**Subject: Evergreen Ridge PUD, Rockberry Loop (LPF-19-00001) Final Long Plat – Staff Review and Request for Additional Information**

TO: Community Development Services  
FROM: Taylor Gustafson, Environmental/Transportation Planner TG  
DATE: February 28, 2019  
SUBJECT: Evergreen Ridge PUD Rockberry Loop LPF-19-00001

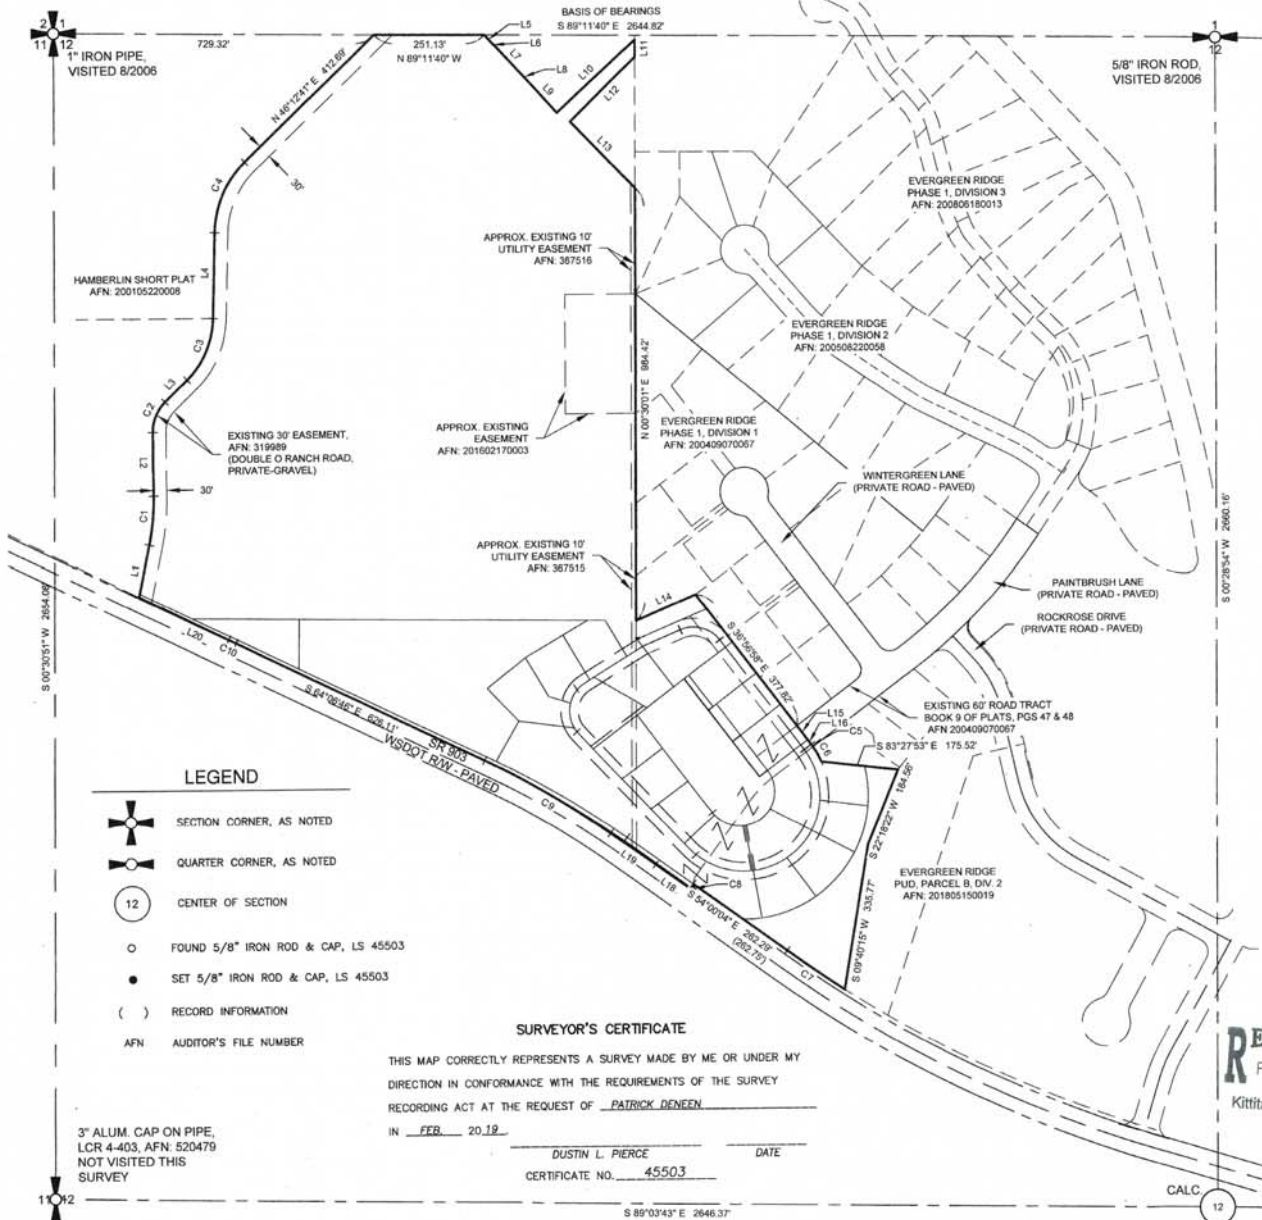
#### Sheet 1

1. The direction of lines L6 and L8 are unclear. A detail window would correct.

KITTITAS COUNTY WASHINGTON		
DWN BY D.L.P./G.W.	DATE 02/2019	JOB NO. 16078
CHKD BY D.L.P.	SCALE 1" = 100'	SHEET 2 OF 6

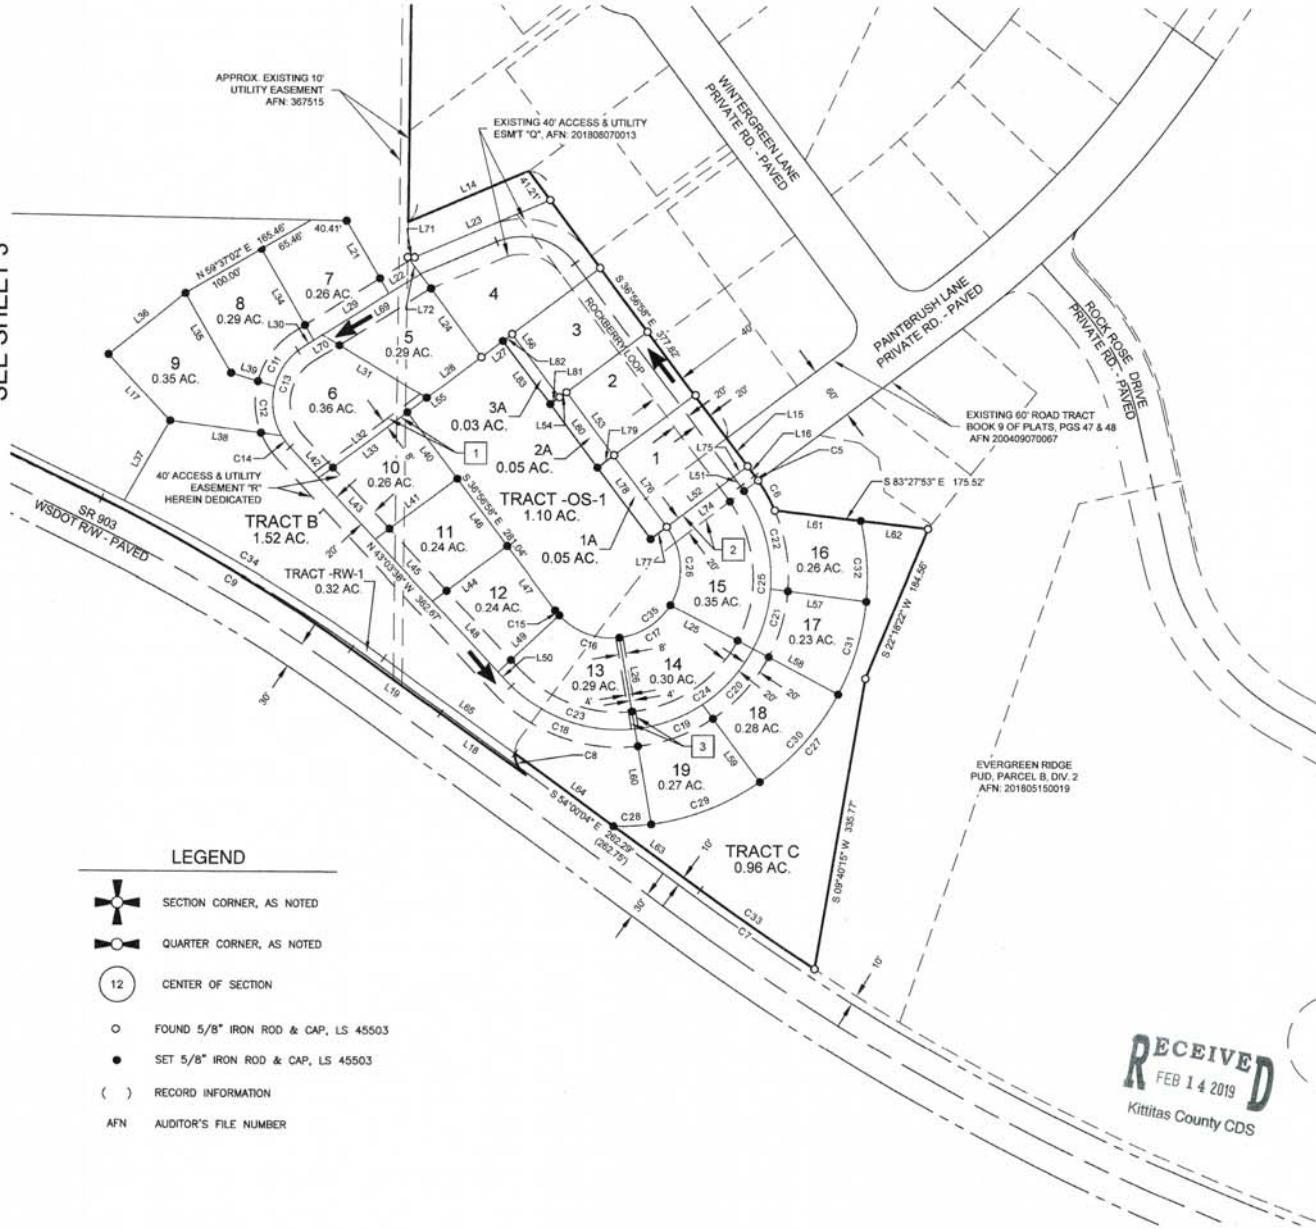
#### Sheet 2

2. The North line of Lot 7 does not show a bearing. Showing the total length (940.41) of the line would also assist in relating Sheet 2 to Sheet 3.
3. Lots 1-4 should show the record document used to create them.
4. The NW line of Lot 10 (L33) does not match closure report. (Report shows S53°03'22"W)
5. The NWmost line of Lot 16 (L75) does not match closure report (Report shows 20.00')

6. The Southernmost Arc on Tract RW-1 is a Non-tangent Arc. Please include a radii or tie to center of arc to make it retraceable.

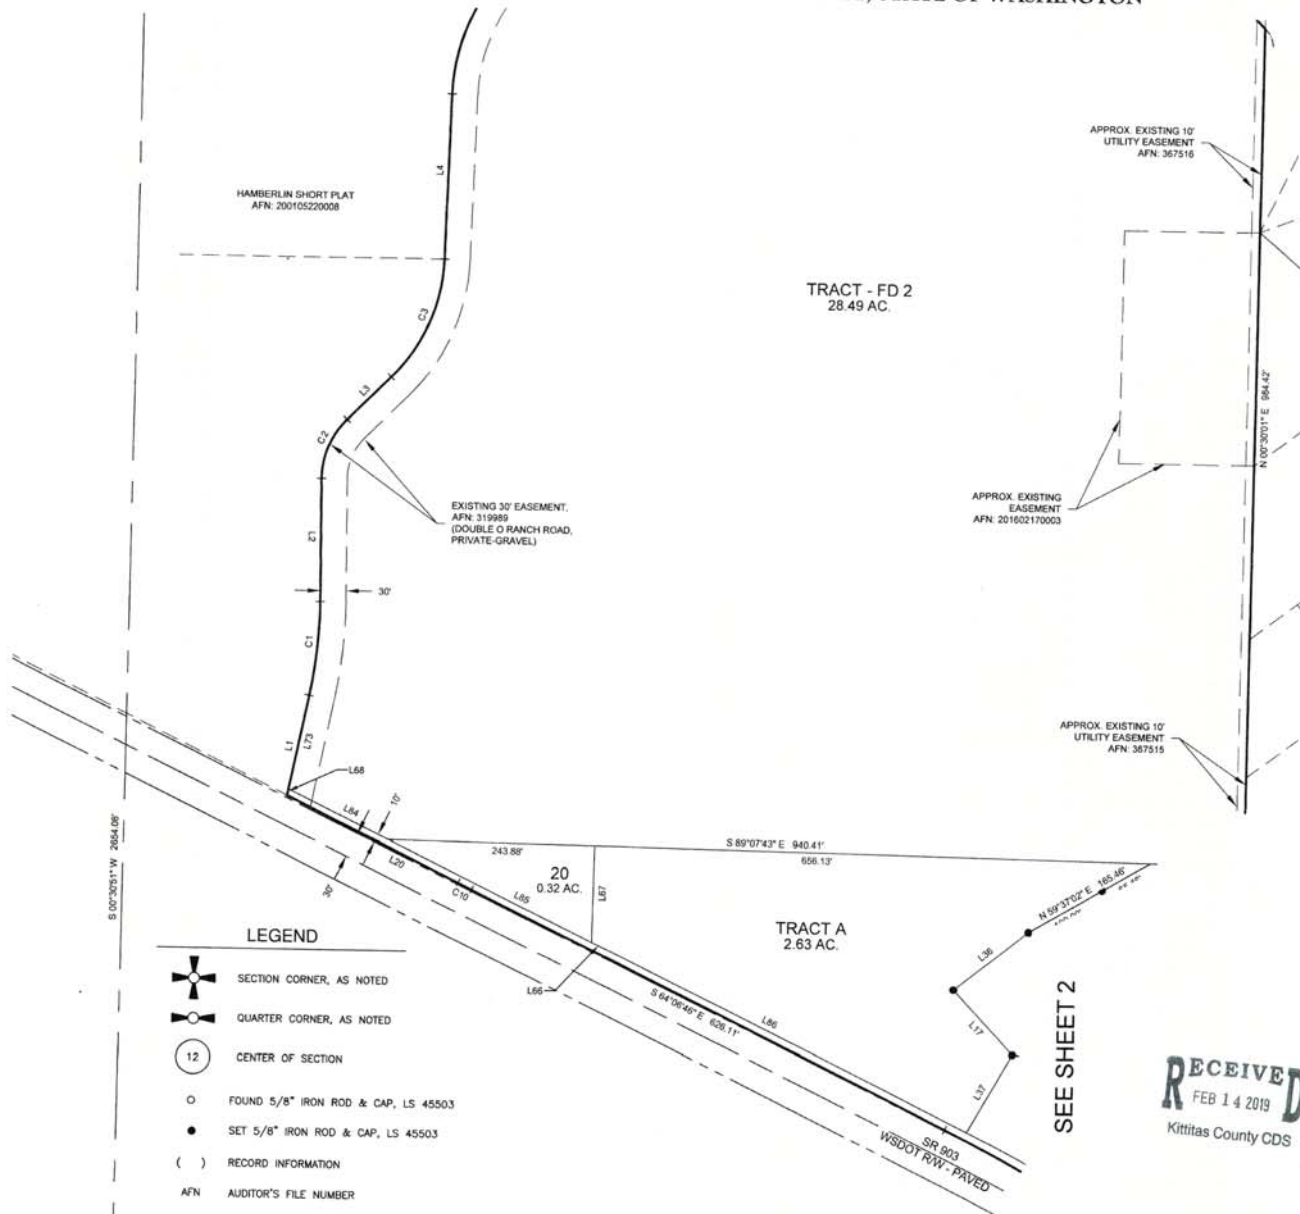
Sheet 3

7. The dimensions near the Easternmost corner of Tract A have been cut off. Please fully include or exclude these dimensions.
8. Identify Tract RW-1 on sheet 3.
